Ein cyf/Our ref: CAS-119508-X9Z4
Eich cyf/Your ref: Cwm Hafren Field

STATUTORY PRE-APPLICATION CONSULTATION - TOWN AND COUNTRY PLANNING (DEVELOPMENT MANAGEMENT PROCEDURE) (WALES) ORDER 2012 AS AMENDED.

BWRIAD / PROPOSAL: Build a holiday park, to include creation of vehicular access and installation of sewage treatment plant.

LLEOLIAD / LOCATION: Cwm Hafren Field, Newtown

Drawing Number: 567-20-15 Revision:

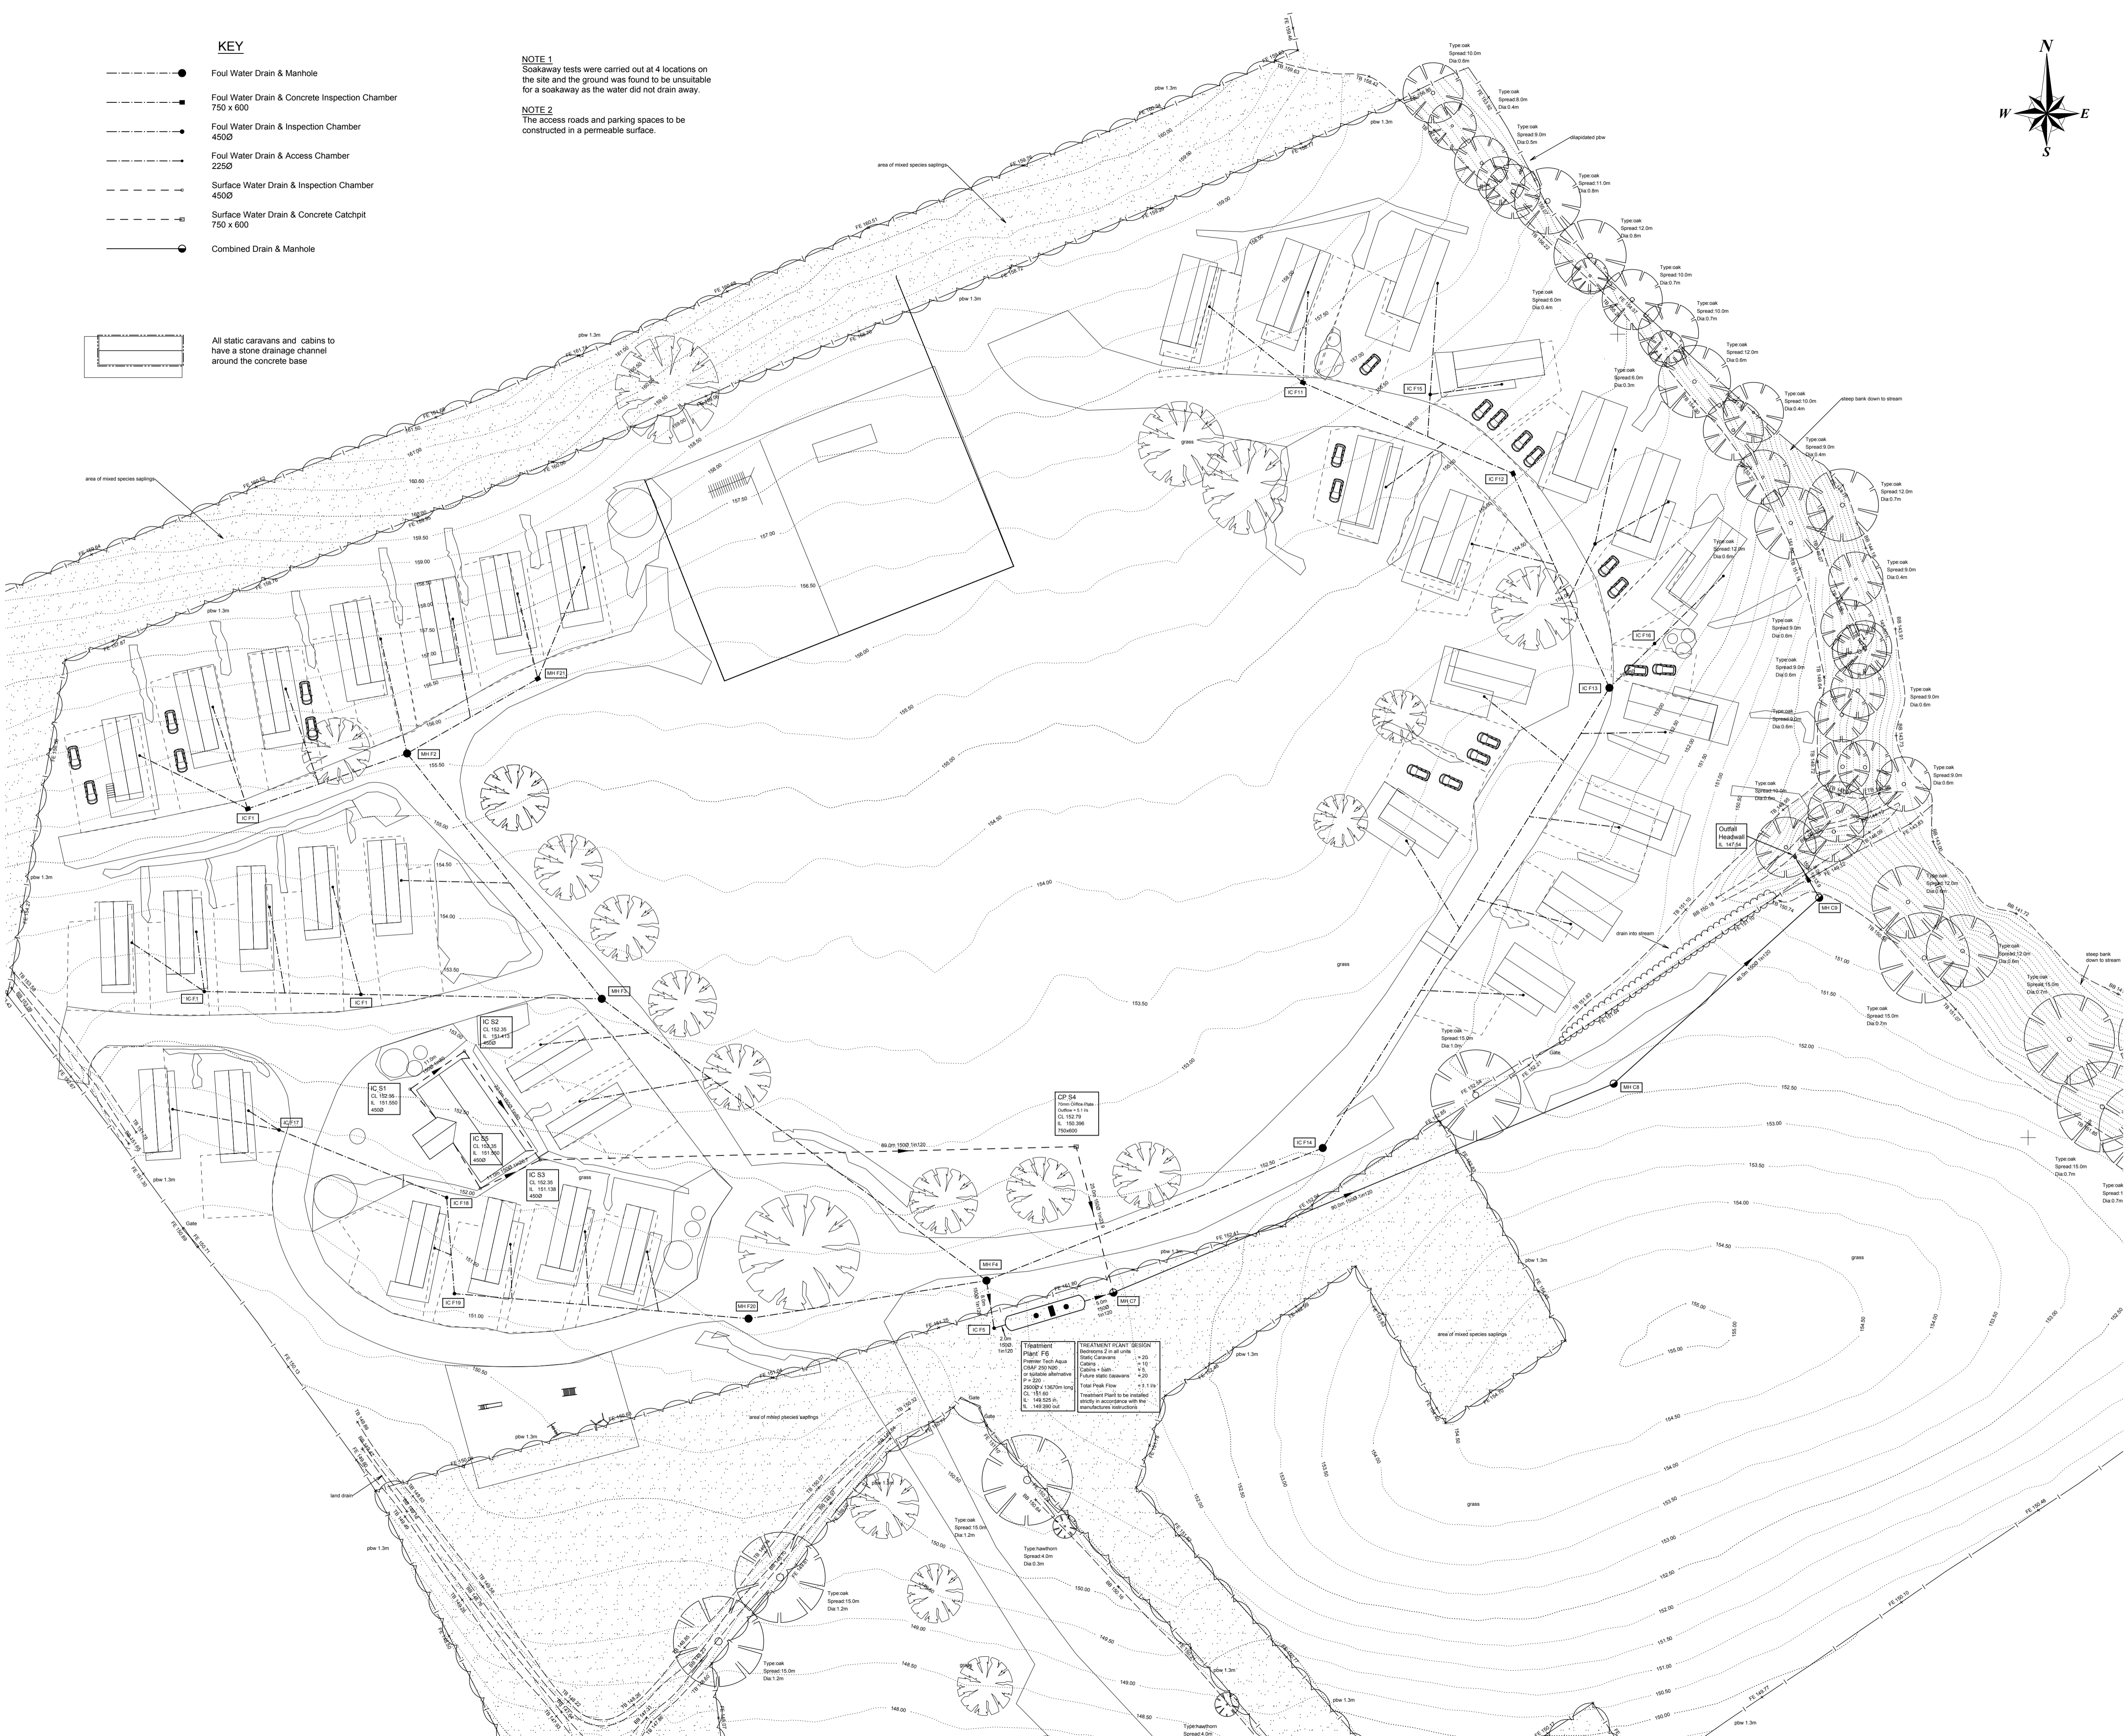
We note that the intention is to dispose of foul drainage to a private sewerage system, i.e. 2 Package Treatment Plants (PTP). According to our records, the proposed development is located within a publicly seweraged area. The Severn Trent Sewer Line runs along the B4568. The installation of private sewage treatment facilities within publicly seweraged areas is not normally considered environmentally acceptable because of the greater risk of failures leading to pollution of the water environment compared to public sewerage systems.

We therefore require the Applicant to either amend their proposals to ensure that the foul drainage is connected to the mains sewerage system or provide detailed evidence to demonstrate that it is not reasonable to connect.

Requirement 1- Foul drainage: site to be connected to the mains sewerage system or satisfactory evidence to be provided to demonstrate that it is not reasonable to connect to mains.
